From: Andrew Leon <andrew.leon@mercerisland.gov>
Date: Friday, June 18, 2021 at 6:09 PM
To: Chris Niederman <Chris@niederman.com>
Cc: Mercer Island ePermit Tech <epermit.tech@mercergov.org>
Subject: 2015-227 Planning Review Comments

I have completed my first round of review of your building permit to install an automatic electric gate at 6800 96th Ave SE, as process under permit number 2105-227. I have the following review comments:

SHEET NUMBER
SK-2

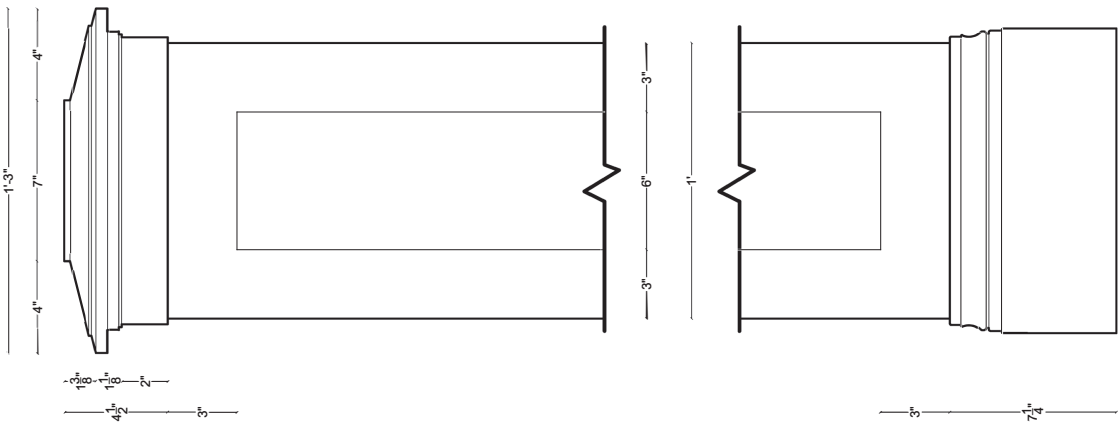
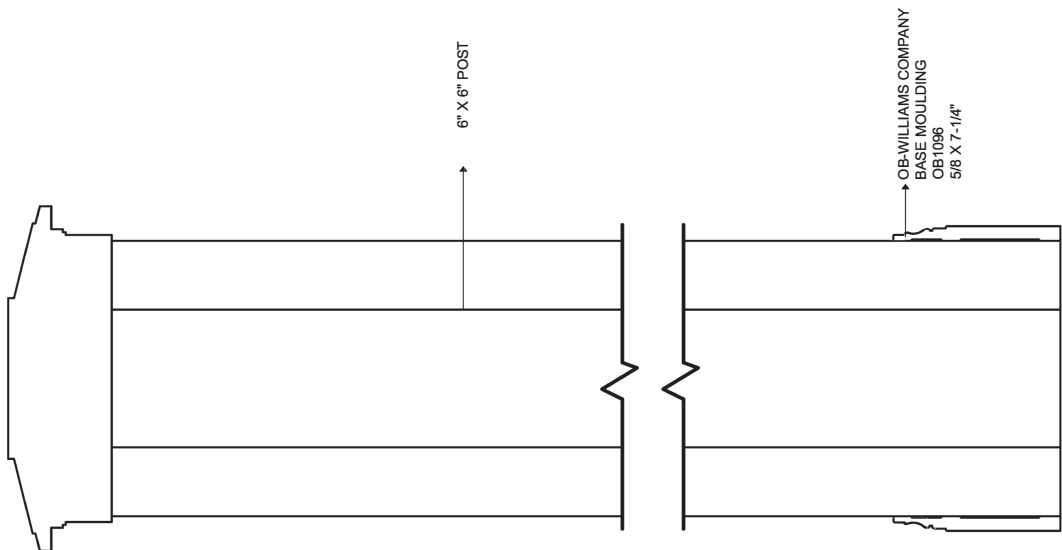
MIC 19.02.050(C)(1) states that the height of a fence is measured from the top of the fence, including posts, to the existing grade or finished grade, whichever is lower, directly below the section of the fence being measured. The lights are part of the posts, so they would also need to meet the 72-inch height limit for the fence.

- [MICC 19.02.050\(E\)\(1\)\(a\)\(i\)](#) states that fences and gates are allowed to a maximum height of 72 inches within required side yards. Further, [MICC 19.02.050\(C\)\(1\)](#) states that the height of a fence or gate is measured from the top of the fence or gate, including posts, to the existing or finished grade, whichever is lower, directly below the section of the fence or gate being measured.

The plans show that the posts of the proposed gate and fence are to be 78 inches in height, with elements extending above 78 inches. This exceeds the 72 inch height limit. Please revise the height of the posts so they meet the height limit listed in [MICC 19.02.050\(E\)\(1\)\(a\)\(i\)](#).

Thank you for sending in this updated document. The revised plans show that the proposed fence and gate meet fence height standards, so I have approved the permit for planning. If you have any questions about how the permit is processed from here, I would recommend getting in contact with the Permit Center at epermit.tech@mercergov.org.
